Engineers Comments Regarding Surface Water Drainage

Subject: Planning Consultation on: AL/18/22/PL

Application No: AL/18/22/PL

Site Address: Lidsey Lodge Farm Sack Lane Lidsey PO22 9PE

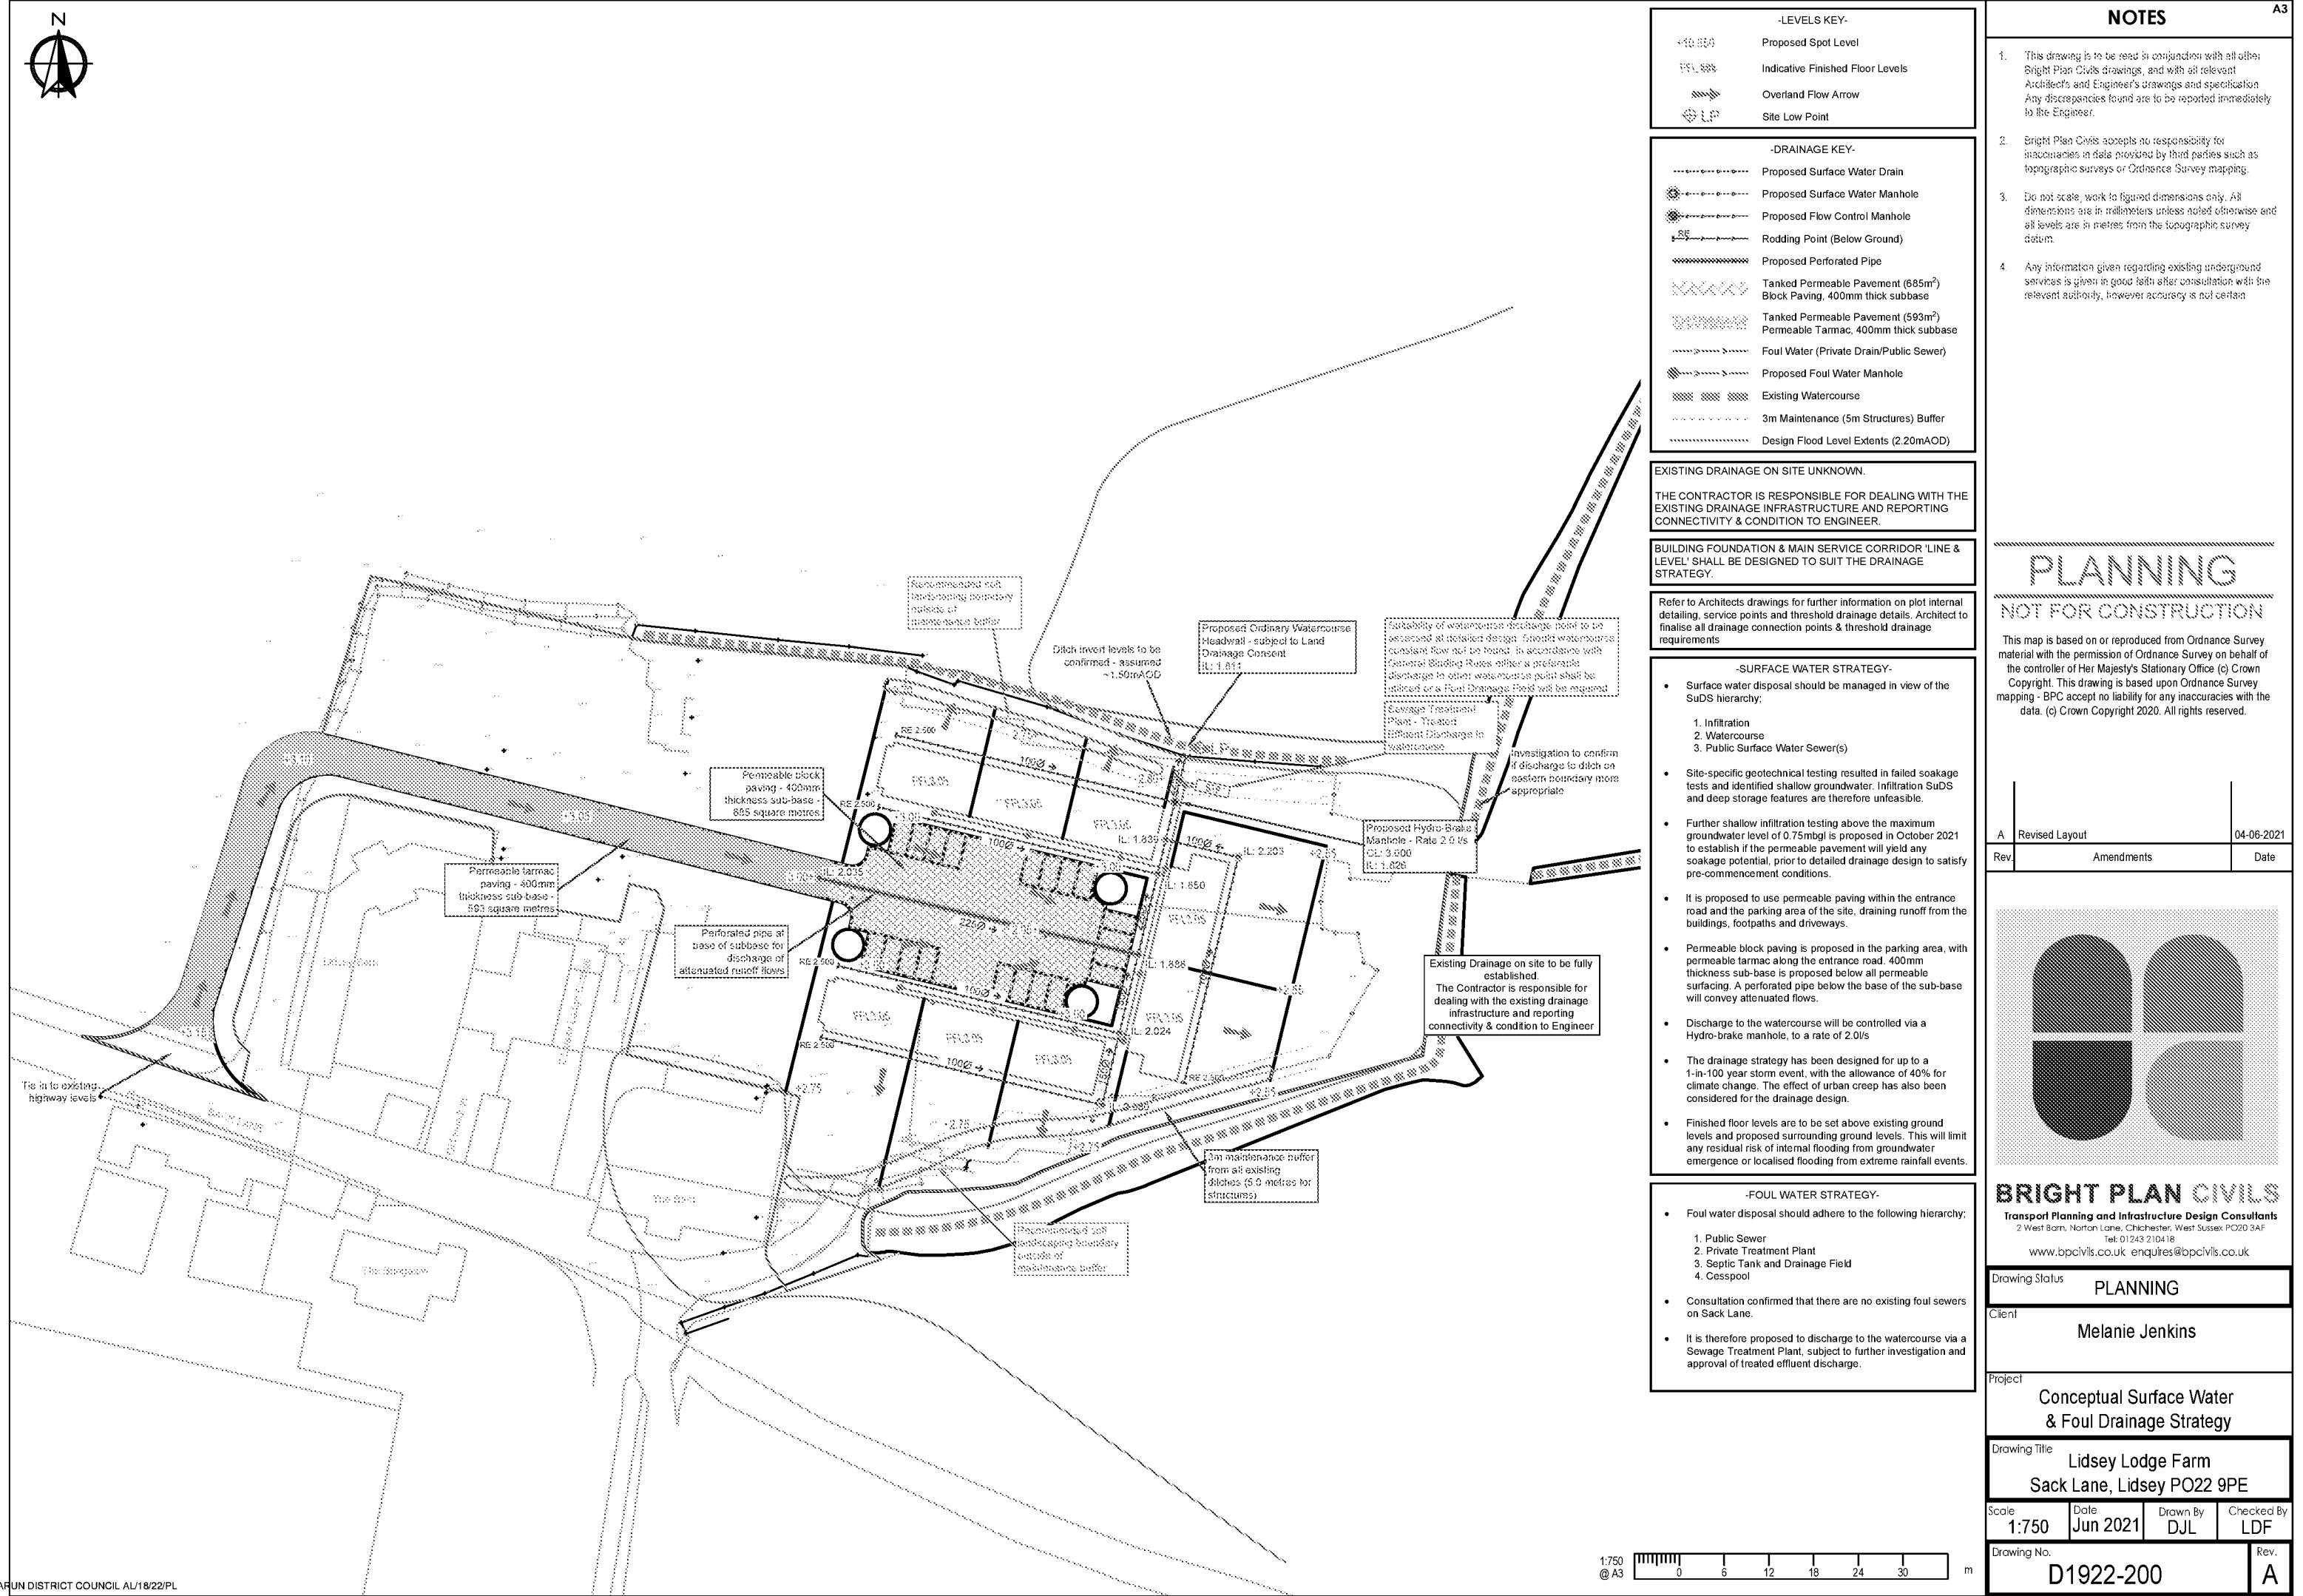
Assuming that infiltration is found to not be viable on the site, then the applicant proposes to dispose of surface water via permeable paving which provides water treatment and storage before discharging at a restricted rate of 2l/s to the watercourse at the north of the site. We are agreeable to this solution, as groundwater did not peak above 0.75mbgl we would like to see the permeable paving lined with a permeable liner to make use of whatever limited infiltration potential there may be on the site.

The applicants engineers are aware of the required easements to the watercourse as these are cited within the FRA. Please ensure that not only buildings, but also boundary fences are not sited within 3m of the watercourses. Please provide a plan showing the buffers and the flood zones when a Discharge of Conditions application is made (if this application is approved).
